From: Sue Howell
Sent: 26 March 2019 14:49
To: Planning.Responses
Cc: Andrew Wood
Subject: RE: Planning Consultation on LU/11/19/DOC

APPLICATION LU/11/19/DOC

Site Address: The Locomotive Inn 5 Terminus Road Littlehampton BN17 5BS

Description of Works: Approval of details reserved by condition imposed under ref LU/45/16/PL relating to Condition No 3 materials, Condition No 4 landscaping, Condition No 5 cycle parking and Condition No 6 site construction.

scale 1:100 drg no. 3490-PC02

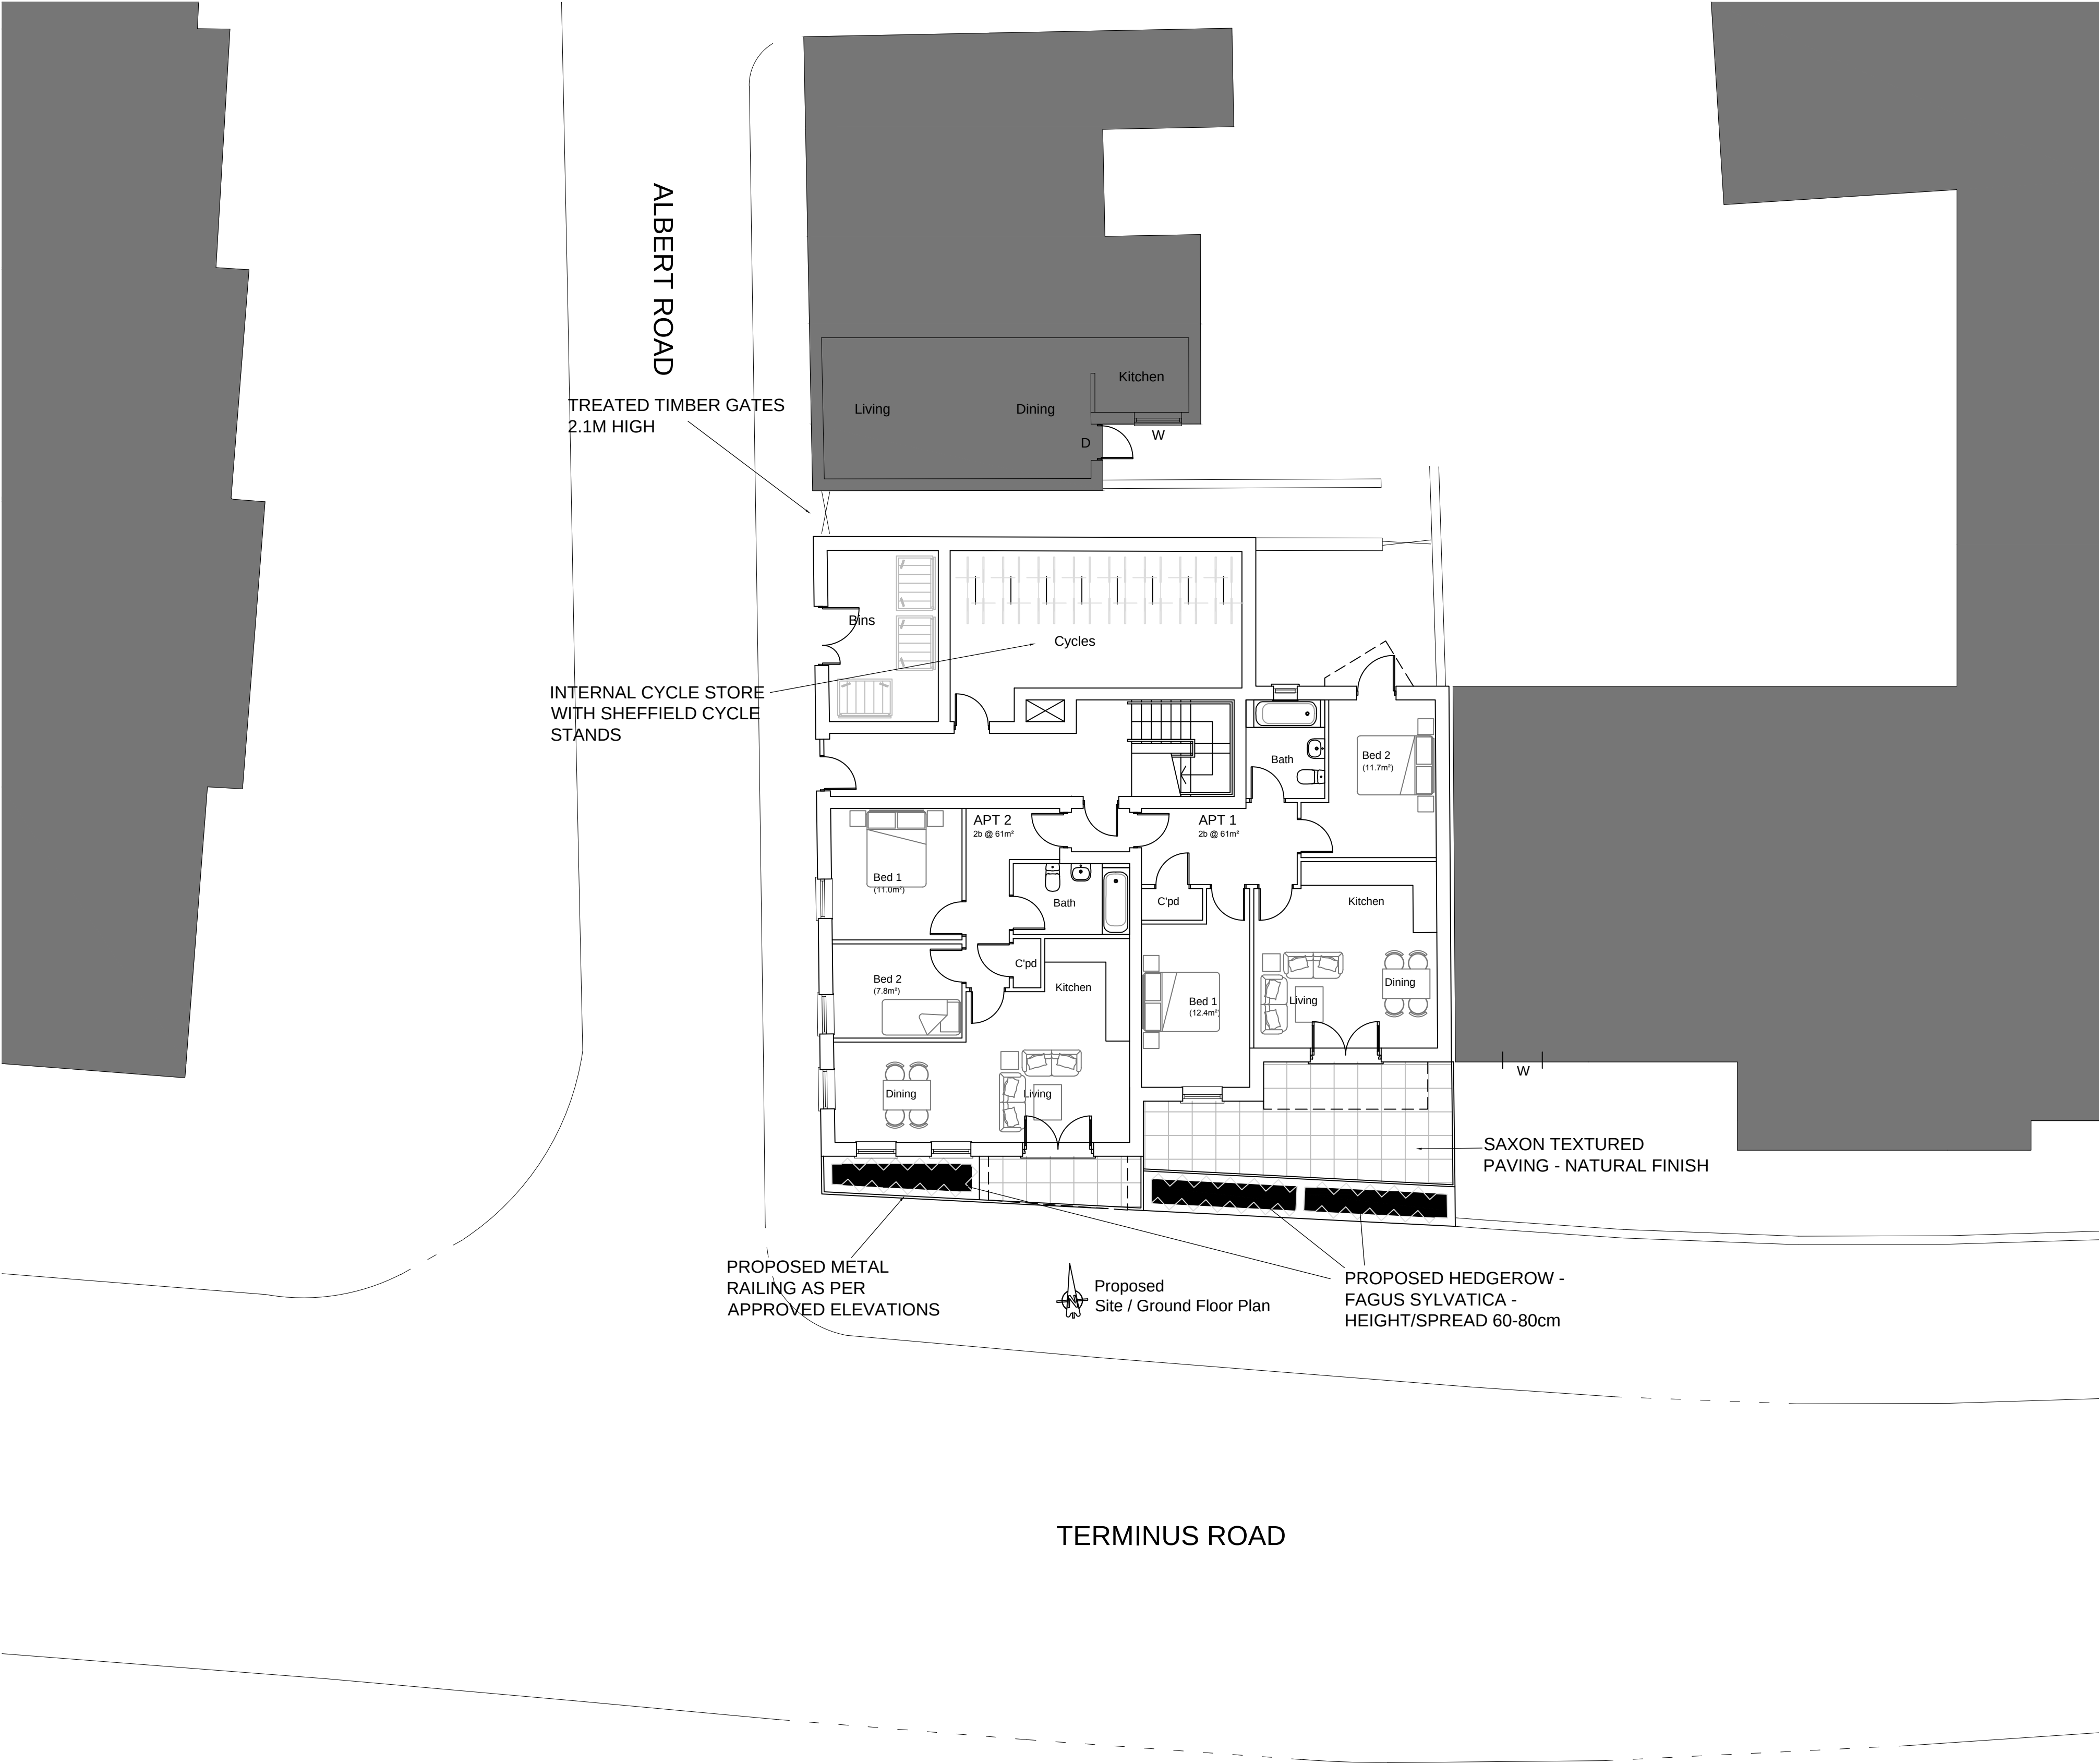
The details submitted in landscaping plan dwg 3490-PC01 do not give the plant quantities, confirmation of which is required for clarity.

I would **not recommend discharge of condition 4** on application LU/11/19/DOC until the plant quantities and the planting density for the planting areas are confirmed.
